# DEPARTMENT OF PLANNING

### SUBJECT: 78-96 ARNCLIFFE STREET AND 31-45 PRINCES HIGHWAY WOLLI CREEK - ROCKDALE LOCAL GOVERNMENT AREA

To determine a modification request for the 78-96 Arncliffe Street and 31-45 Princes Highway, Wolli Creek – Rockdale Local Government Area.

**SIGN SD8 - SIGNAGE DAN MURPHY'S**

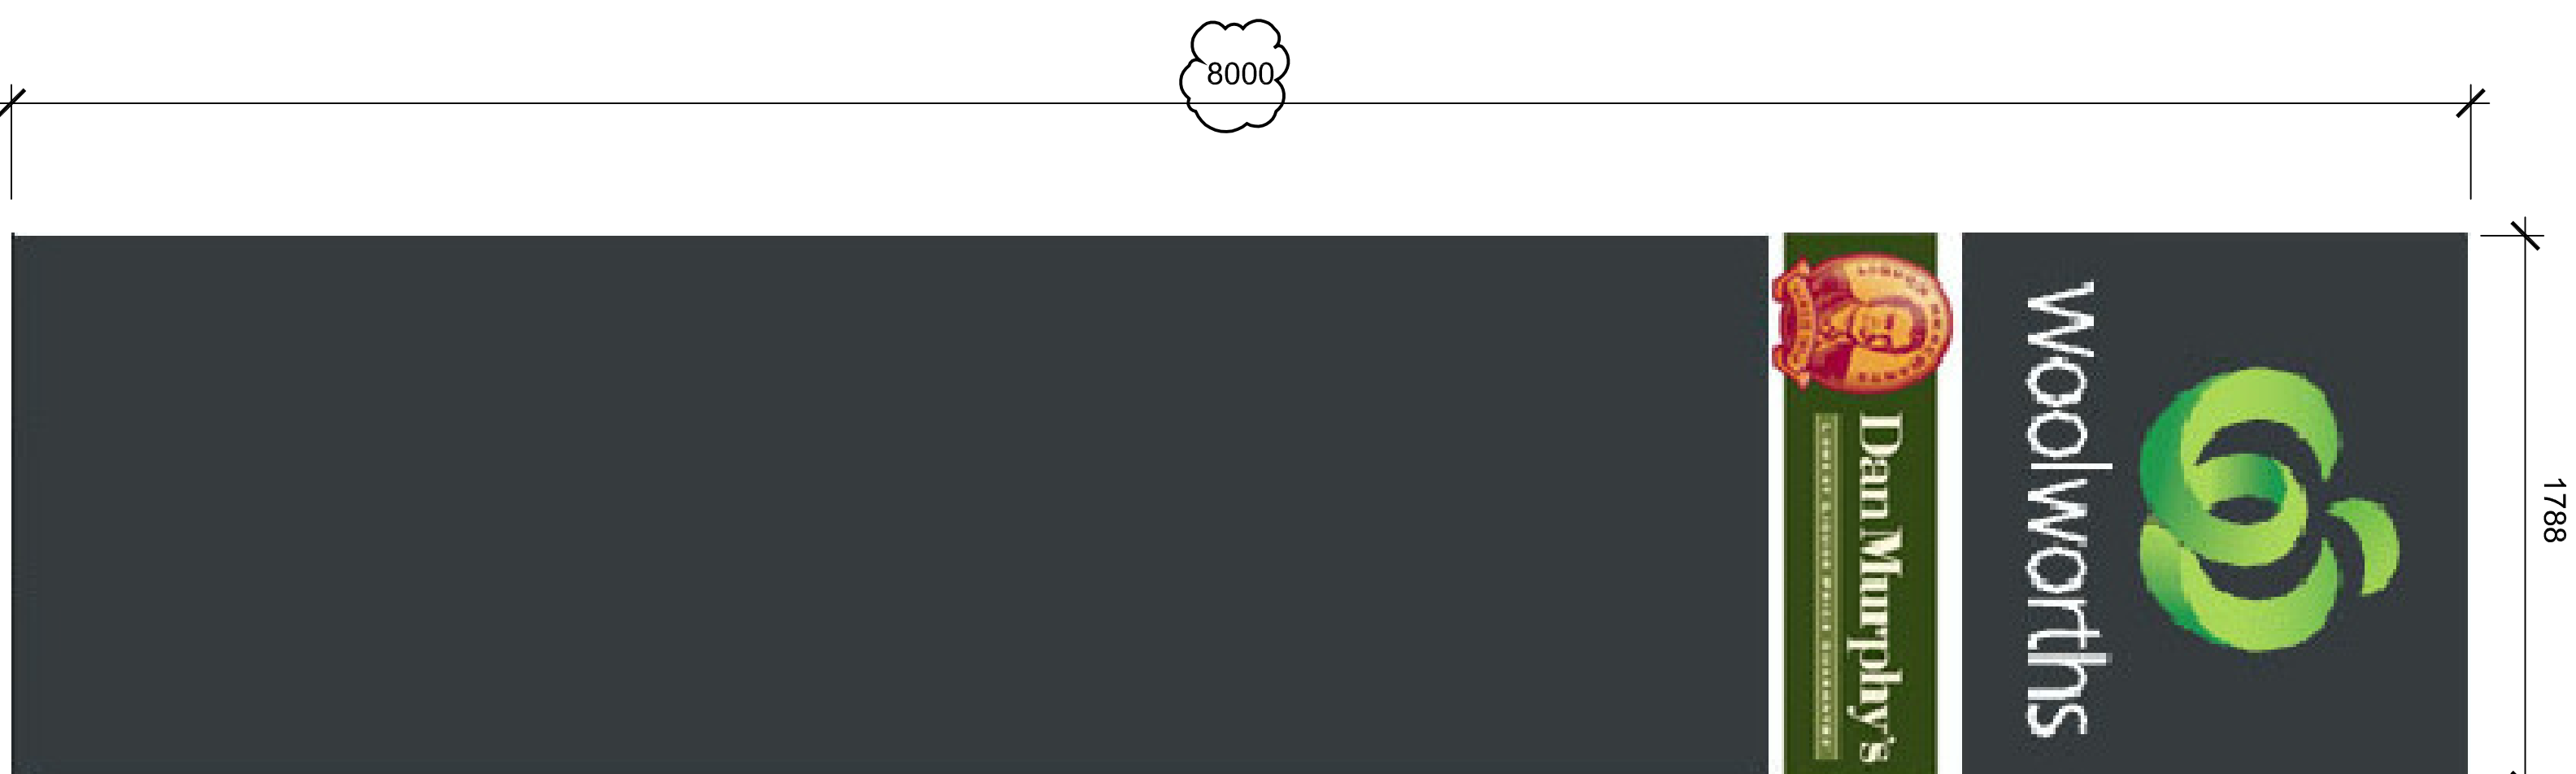
- Signage – The proposed signage should be should subject to a separate application to be determined by Council in accordance with condition B3.
- Notification – The application should be notified given the potential adverse impacts on adjoining residents as a result of the proposed extension of loading dock hours.

The modification request seeks inclusion of signage as part of the development approval. 15 signs are proposed relating to future occupation of the site. The signage plans provided are for "Woolworths" and "Dan Murphy's" tenancies.

Condition B3 of the approval required that signage and internal fitout of retail areas must be the subject of separate development applications to Council. The proponent fails to justify the need for approval of signage as part of the development by the Department and it is appropriate that the condition remain.

NORTH EASTERN ELEVATION SCALE 1:100

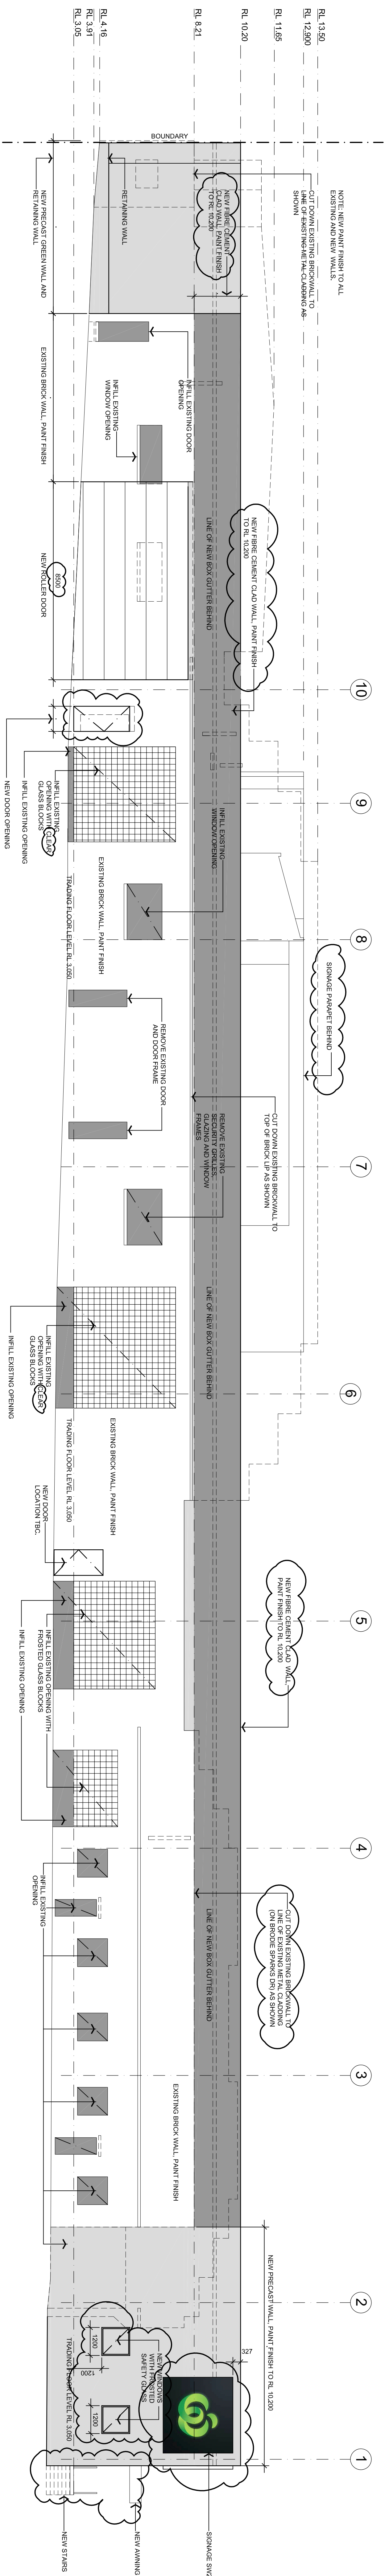
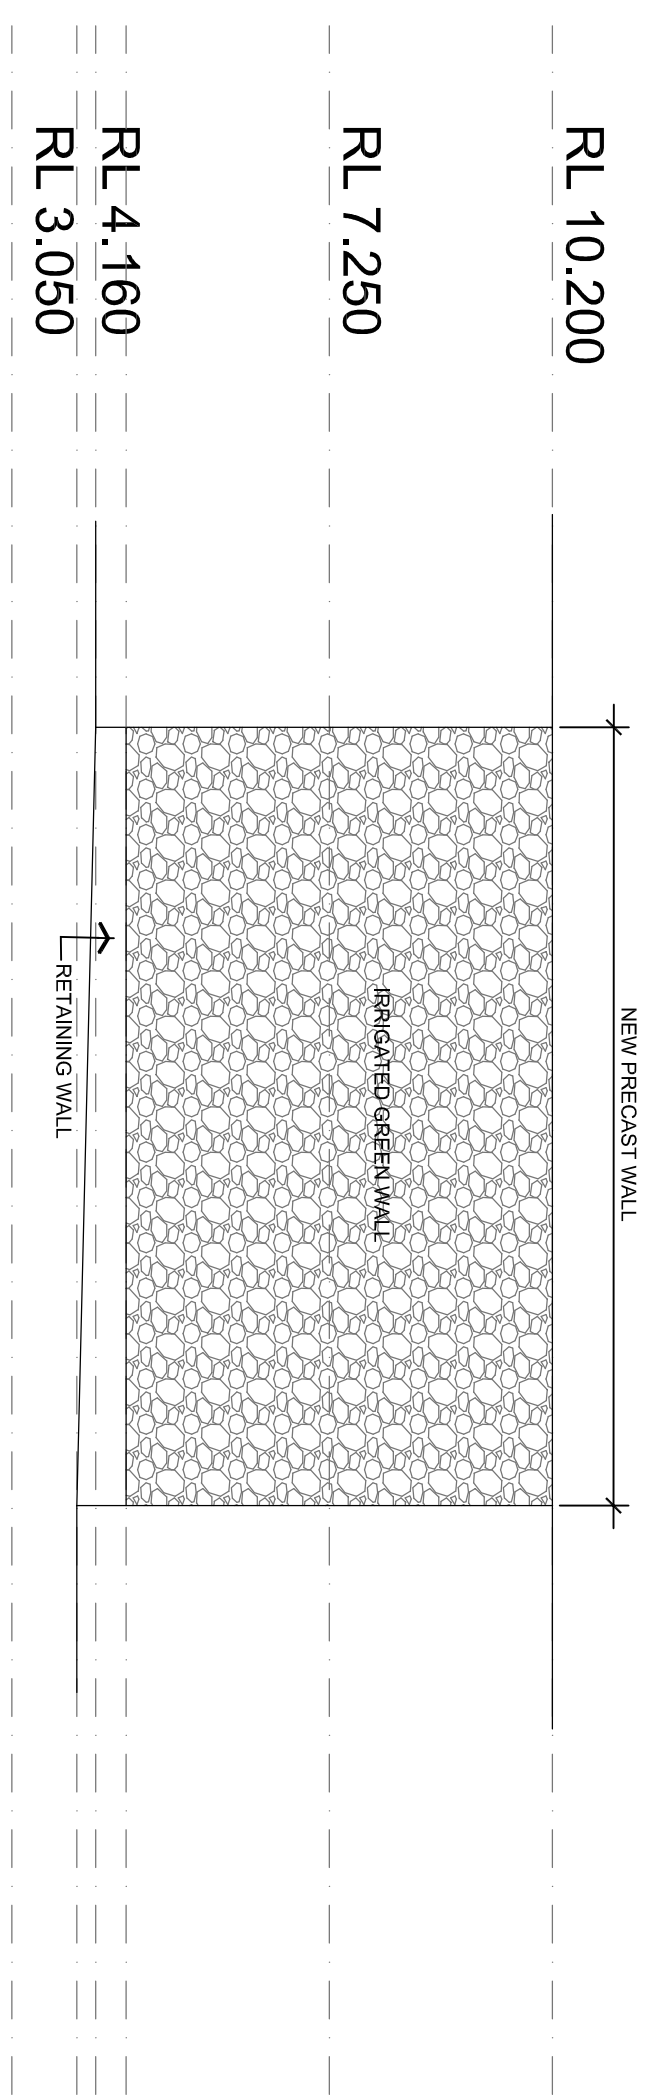
- Urban design - The increase in building footprint will impact upon the aesthetics and visual amenity of the site, particularly along Brodie Spark Drive and reduce the area available for landscaping. In addition the amended schedule of finishes is not supported and it is recommended that Council be consulted prior to finalisation of schedule of finishes given the significance of the site. Council also identified that there have been a range of minor changes to façade detailing which have not been detailed in the application by the proponent.

Council raised concerns that the Proponent's submission did not adequately explain or detail all the changes made to the plans. The Department has reviewed the approved and modification plans and while there are some minor changes evident, particularly to the Arncliffe Street elevation, this results from a reduction to the amount of demolition proposed which is supported by the Department.
